re: Grading & Servicing Plan Review
Proposed Institutional Building
6600 Carrière Street – Ottawa, Ontario

date: May 15, 2025

file: PG3694-MEMO.03

- ☐ Site Servicing Plan – MIFO – 6600 Carrière Street – Project No.106134-00 – Drawing No. 21-5089A – Revision 7 dated December 20, 2024.
- ☐ Site Grading and Drainage, Erosion and Sediment Control Plan – MIFO – 6600 Carrière Street – Project No.106134-00 – Drawing No. 21-5089A – Revision 7 dated December 20, 2024.

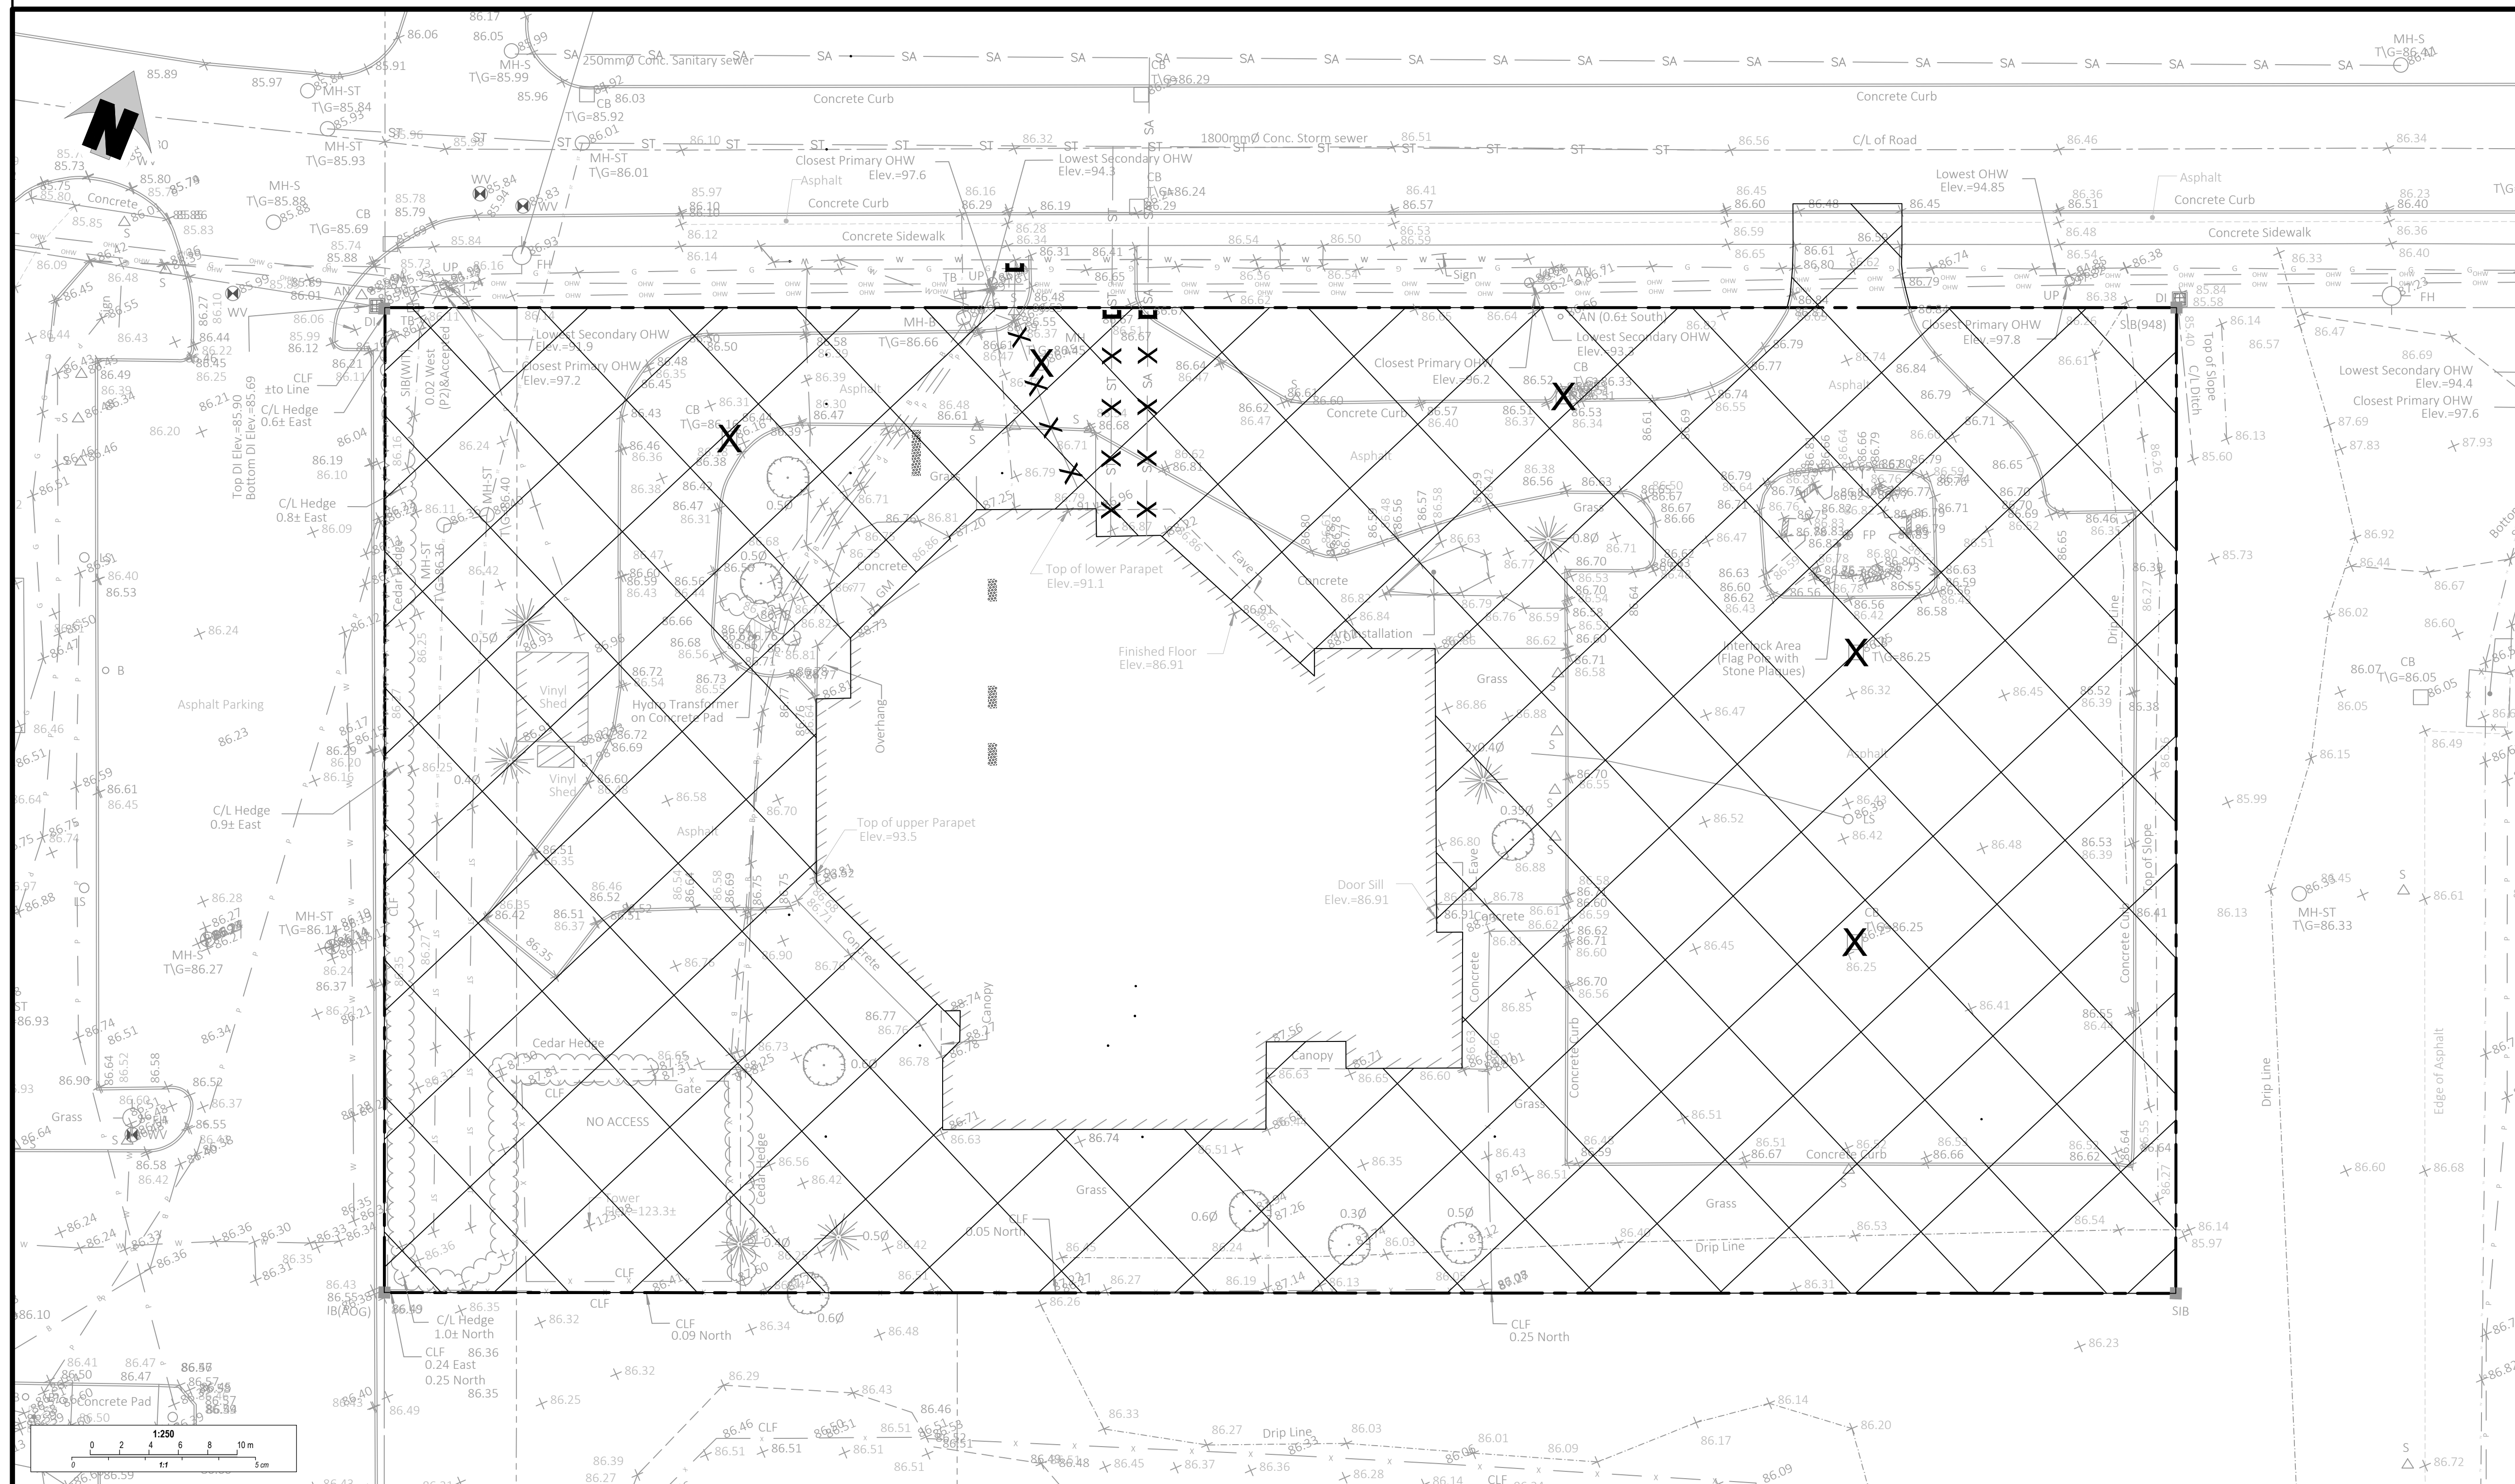
In reviewing the Site Servicing Plan, referenced above, the proposed services have sufficient frost cover. Therefore, the site servicing design is considered acceptable, from a geotechnical perspective, and no insulation is required for the proposed servicing pipes.

C2

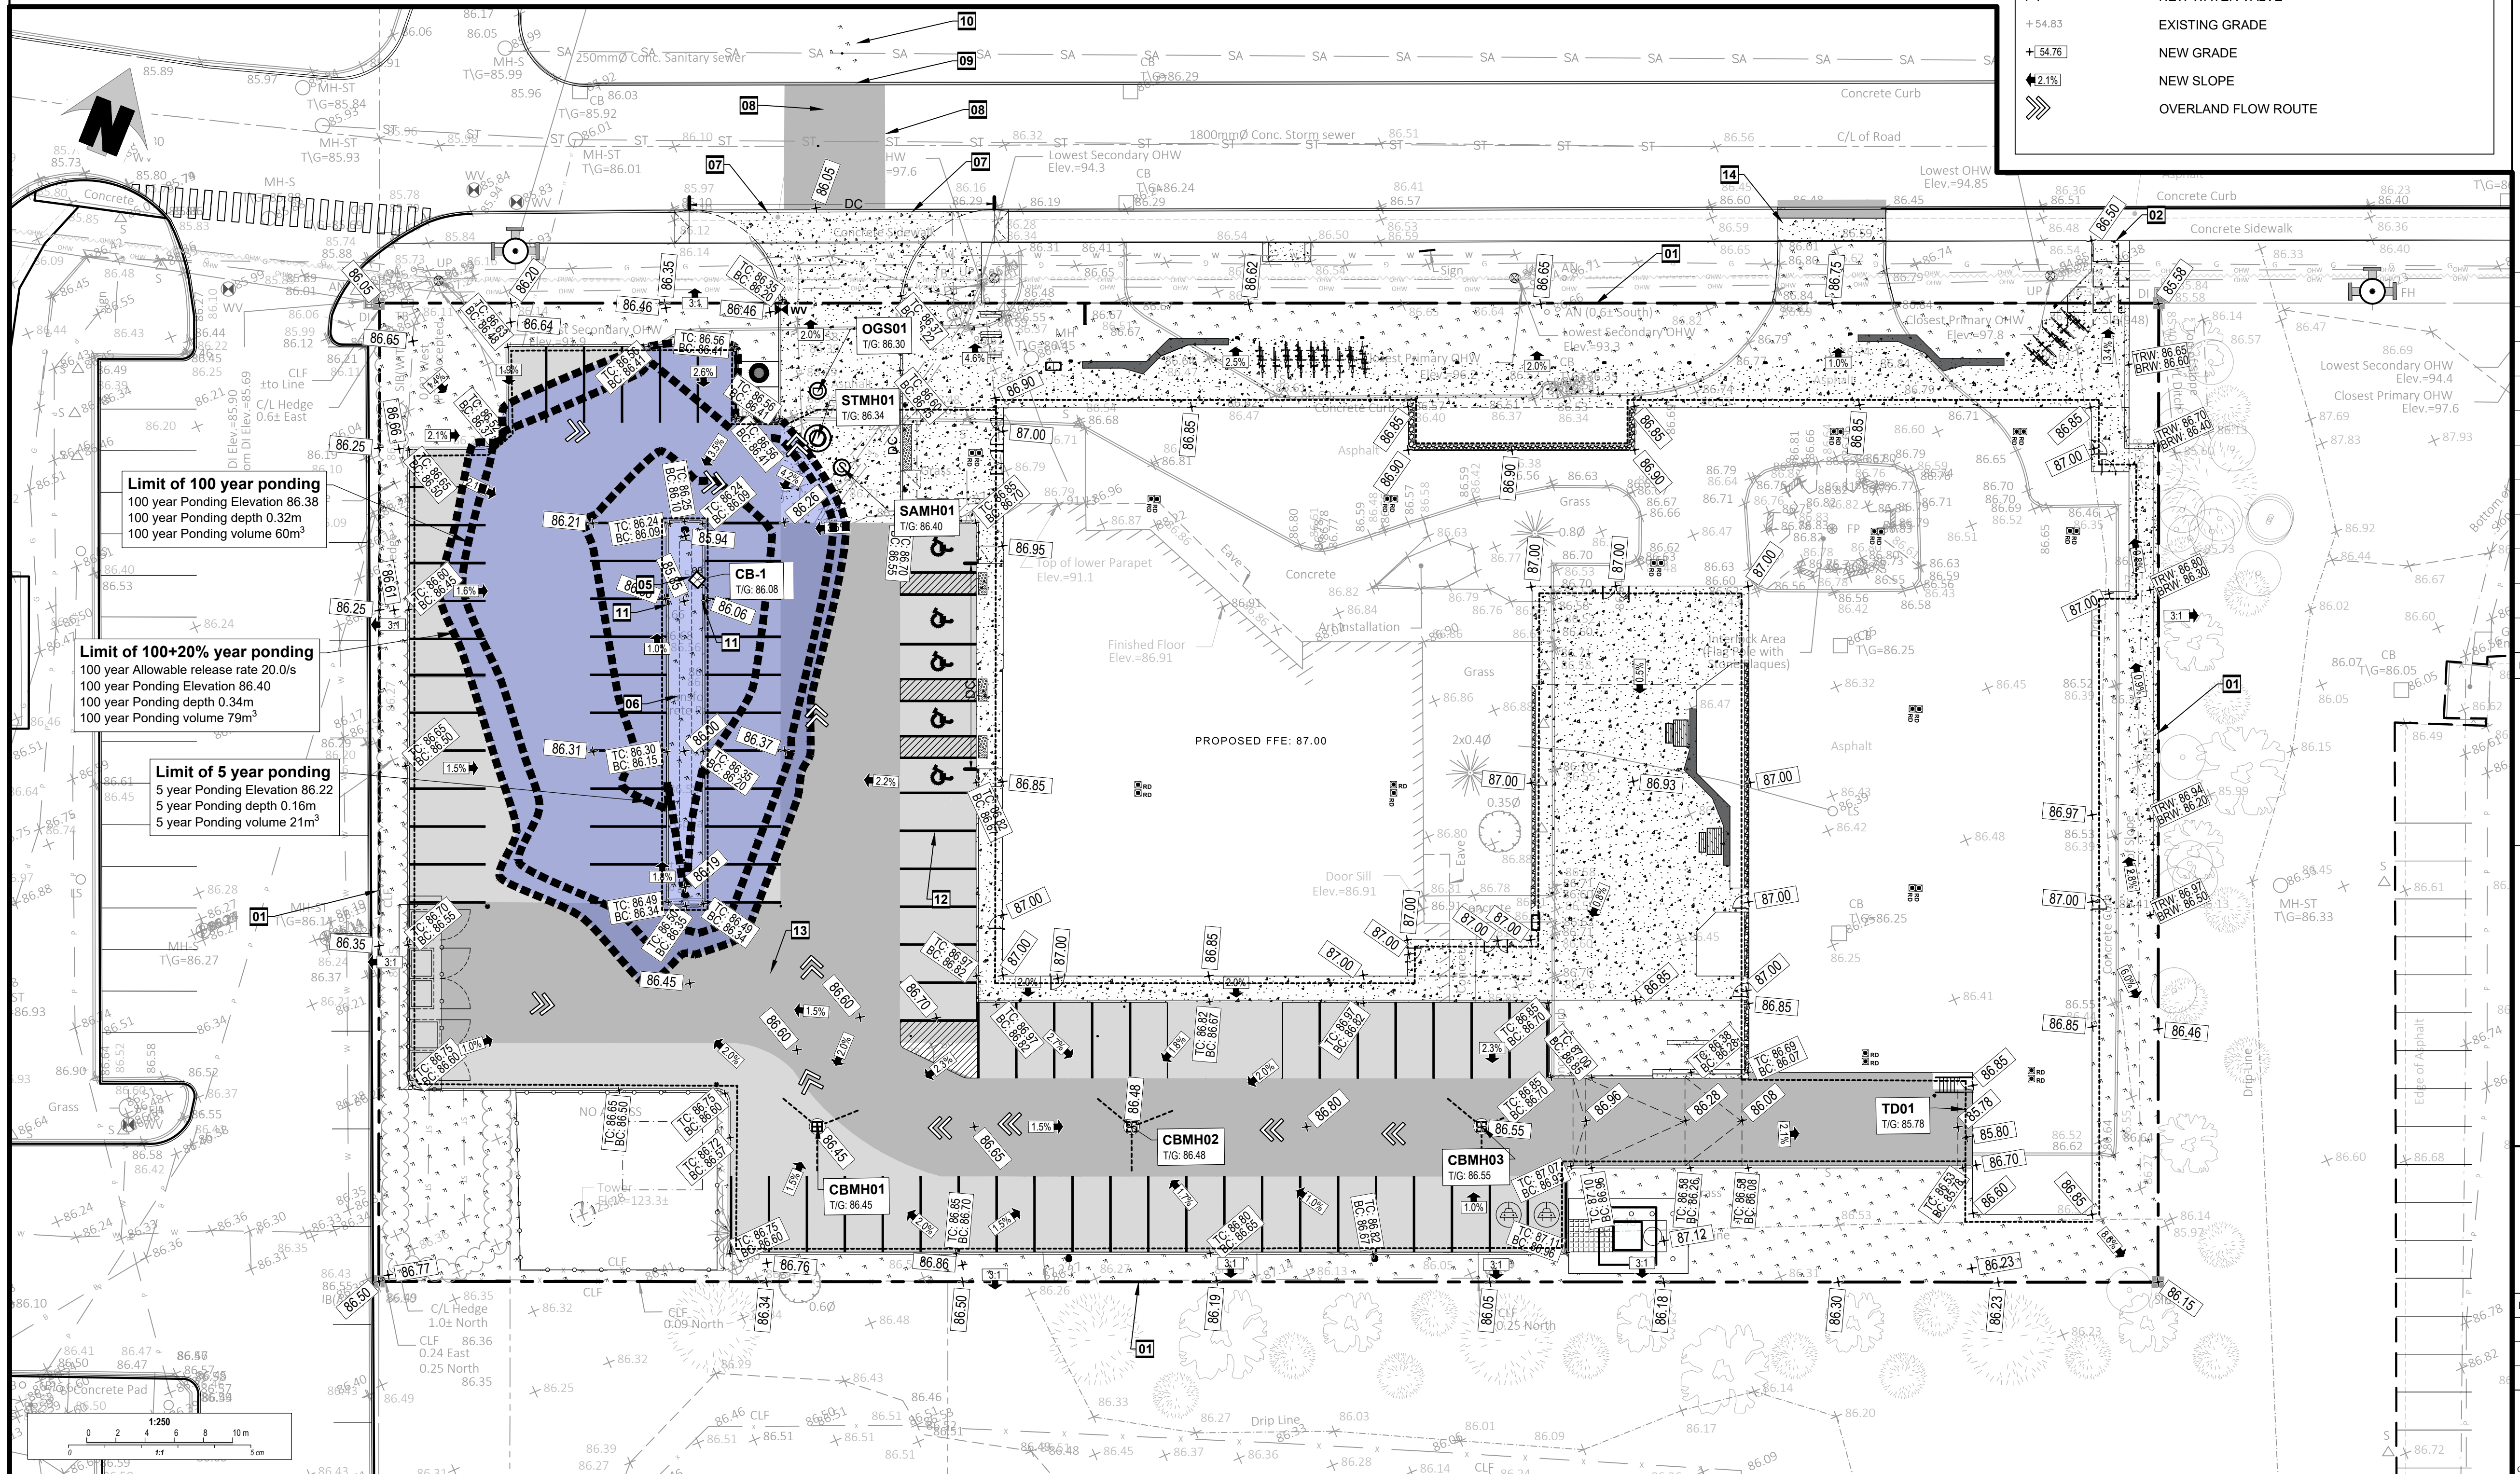
Based on our review of the above-noted grading plan, the proposed grading at the subject site is generally within the recommended permissible grade raise restriction of 0.5 m provided in the Geotechnical Investigation Report, referenced above. There are localized areas exceeding the permissible grade raise by approximately 0.05 to 0.2 m, however, these localized grade raises are considered minor, and have been reviewed and are considered acceptable. Therefore, the proposed grading is considered acceptable, from a geotechnical perspective, and no lightweight fill or other considerations are required to accommodate the proposed grading.
